WELWYN HATFIELD BOROUGH COUNCIL – ESTATE MANAGEMENT SCHEME
DELEGATED REPORT

APPLICATION No:	W6/2013/326/EM
APPLICATION Site:	6 Fordwich Road, Welwyn Garden City

The proposal seeks the installation of roof mounted solar panels, centrally sited across the majority of the width and depth of the south (rear) roof slope. This would mirror the siting and extent of solar panels currently in existence on the south (rear) roof slope of the adjoining property (No.8). The solar panels at No.8 do not currently benefit from Estate Management Consent.

ELEVATIONS 1:100

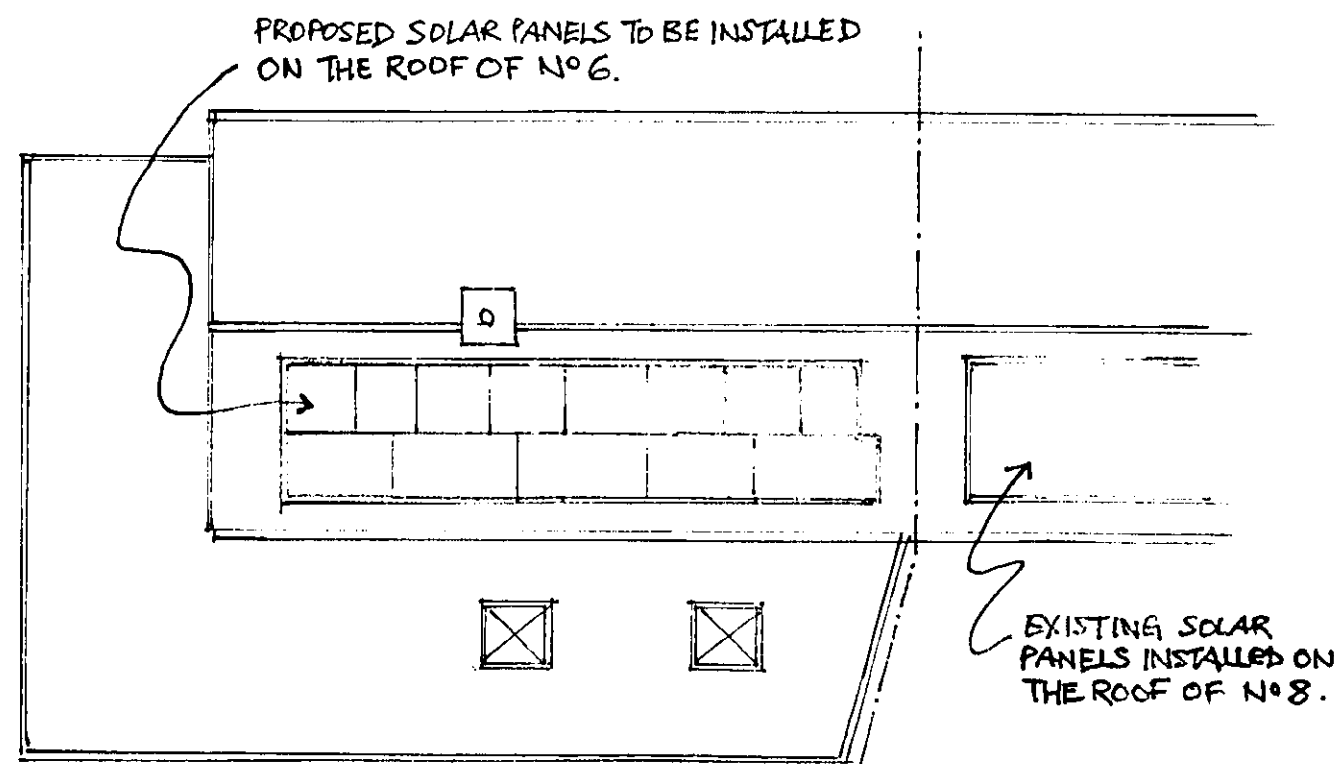
The proposed roof alteration would be sited on the rear/south roof slope. The proposal would have an impact on the street scene because of its location as the property features three elevations (west, north and south) which are prominent from the street scene due to its siting side-on to the street. The solar panels would therefore be visible from the south (rear) and west (side) of the site on Fordwich Road. This is evident as the panels on the south (rear) slope of No.8 which adjoins the application property (which do not benefit from Estate Management Consent) are currently visible from these positions on the street scene. Accordingly, the proposed siting of solar panels would be contrary to the aforementioned policy approach.

Solar panels have not been permitted on the current policy basis on other properties with prominent elevations visible from the street scene in the surrounding area of Fordwich Road. Further to this, solar panels are not considered in keeping with the architectural design and style of the property, which forms part of a terraced block. This is notwithstanding the panels on No.8 for which no consent has been granted and which will be investigated by an enforcement officer. As such, due to the prominent siting of the proposal which would be visible to the south along Fordwich Road, and immediately to the west of the property due to its orientation, alongside the architectural detailing and style of the property, and that of those on the surrounding street scene, the proposal would have a detrimental impact on the character and appearance of the street scene.

It is considered that the proposal, by virtue of its prominent siting which would be visible to the south along Fordwich Road and immediately to the west of the property due to its orientation, and the architectural detailing and style of the property on which it would sit, and that of those on the surrounding street scene, would be detrimental impact to the character and appearance of the street scene. It would be contrary to the policy approach within the Welwyn Garden Estate Management Scheme Areas to deal with roof alterations. It would therefore fail to maintain and

1. It is considered that the proposal, by virtue of its prominent siting which would be visible to the south along Fordwich Road and immediately to the west of the property due to its orientation, and the architectural detailing and style of the property on which it would sit, and that of those on the surrounding street scene, would be detrimental impact to the character and appearance of the street scene. It would be contrary to the policy approach within the Welwyn Garden Estate Management Scheme Areas to deal with roof alterations. It would therefore fail to maintain and enhance the amenities and values of the Garden City and is not compliant with the Estate Management Scheme.
